Lower Thames Crossing

9.53 Comments on WRs Appendix A – Statutory Environmental Bodies

DATE: August 2023
DEADLINE 2

Planning Inspectorate Scheme Ref: TR010032
Examination Document Ref: TR010032/EXAM/9.53

*Local Landscape Character Area boundaries of the Kent Downs AONB LCA, West Kent Downs, Sub-areas Cobham and Shorne*

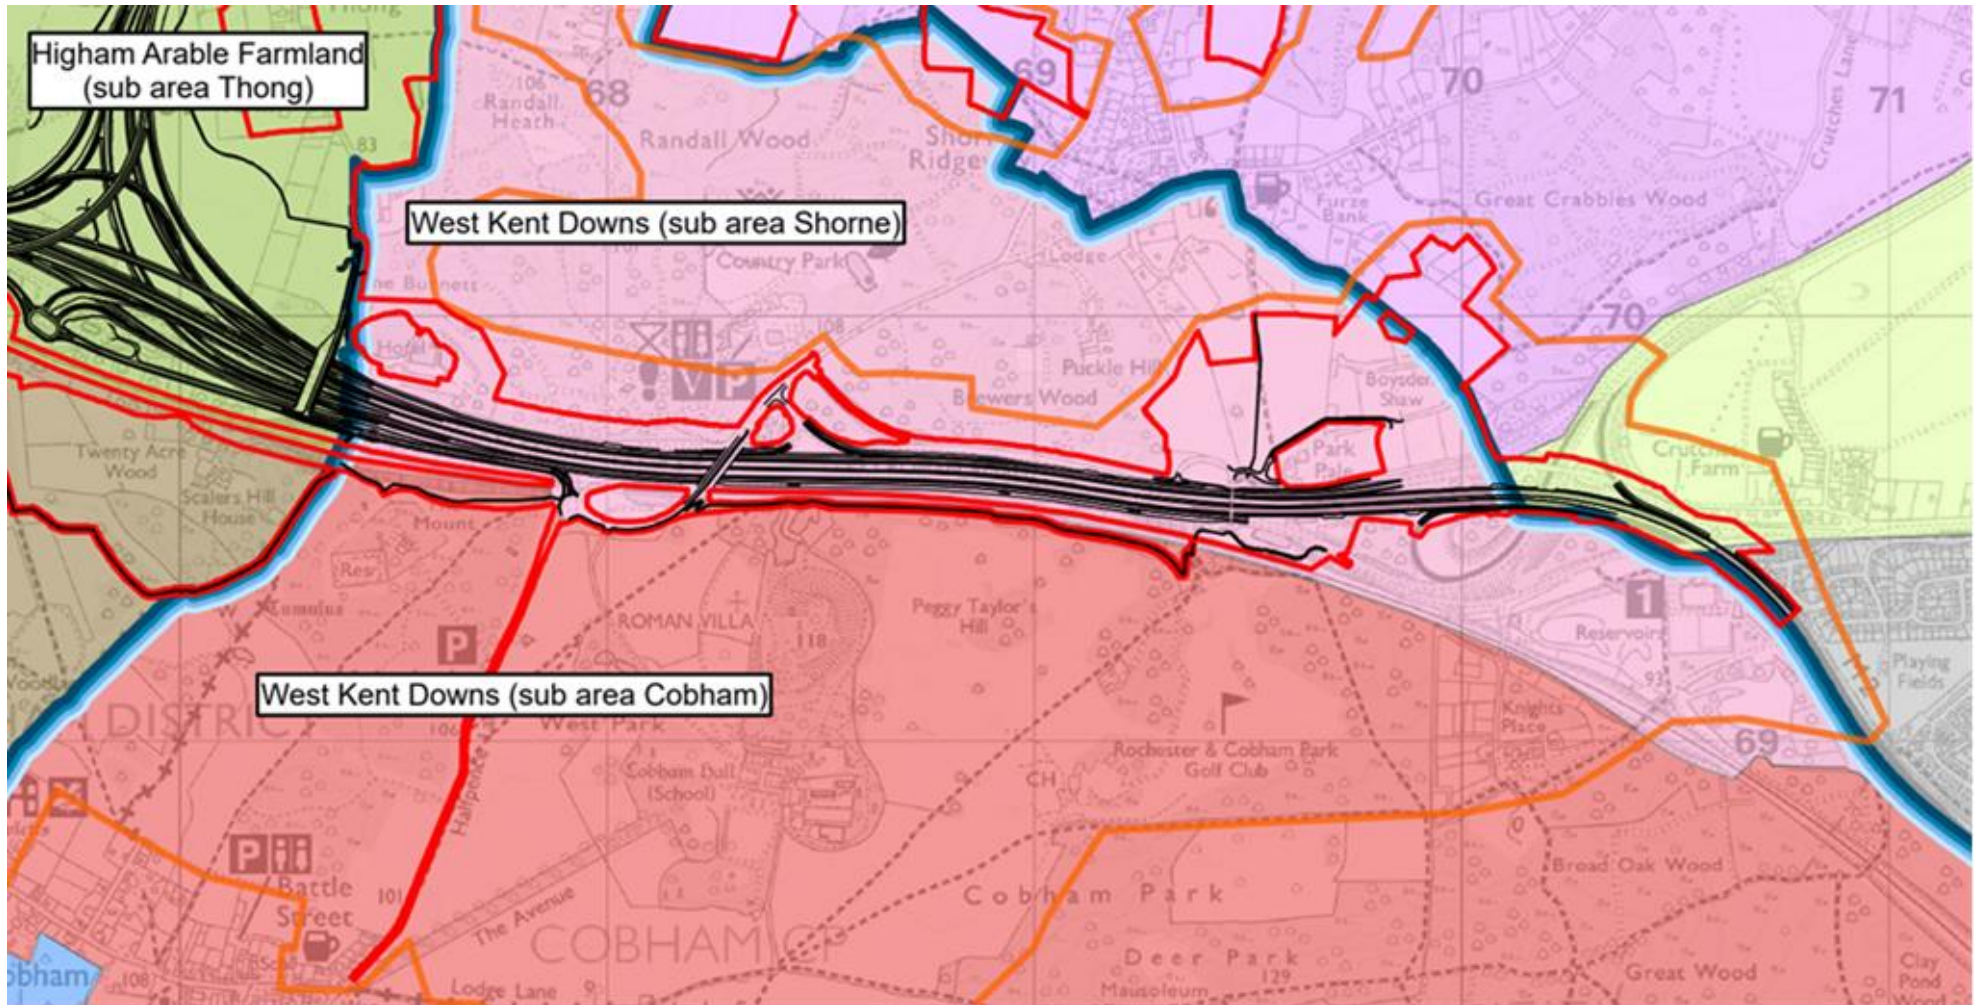
In response to **paragraph 6.1.3, 6.1.4 and 6.1.7**, the boundaries of the Local Landscape Character Areas (LLCA) within the Kent Downs AONB have not been incorrectly transposed. As detailed in Paragraph 7.3.58 of ES Chapter 7: Landscape and Visual [[APP-145](#)]:

From the Applicant's review of the West Kent Downs (sub area Cobham) Local Landscape Character Area (LLCA) and from their site visits, the Applicant has concluded that HS1 and the associated planting strongly define the northern extent of the Cobham sub area and it therefore made sense for the Shorne sub area to incorporate the whole width of the A2 corridor, beyond HS1.

However, notwithstanding the slight difference in the West Kent Downs (sub area Cobham) LLCA boundary shown on Figure 7.2 compared with the Kent Downs AONB Landscape Character Assessment, the effects of the Project are fully assessed either as direct or indirect effects within the West Kent Downs (sub area Cobham) LLCA and/ or the neighbouring West Kent Downs (sub area Shorne) LLCA.

The effects on both the West Kent Downs (sub area Cobham) LLCA and on the West Kent Downs (sub area Shorne) LLCA are assessed in Tables 2.3 and 3.3 of ES Appendix 7.9 [[APP-384](#)]. The findings of these two assessments are then brought together into a combined assessment for the overarching West Kent Downs Landscape Character Area (LCA) 1A identified in the Kent Downs AONB Landscape Character Assessment Update. The combined effects reported in the landscape impact summary Tables 7.33 and 7.34 in Section 7.9 of ES Chapter 7: Landscape and Visual [[APP-145](#)] and the overall conclusion of the landscape and visual impact assessment would therefore not differ if the Cobham and Shorne sub area boundary is drawn in a different location.
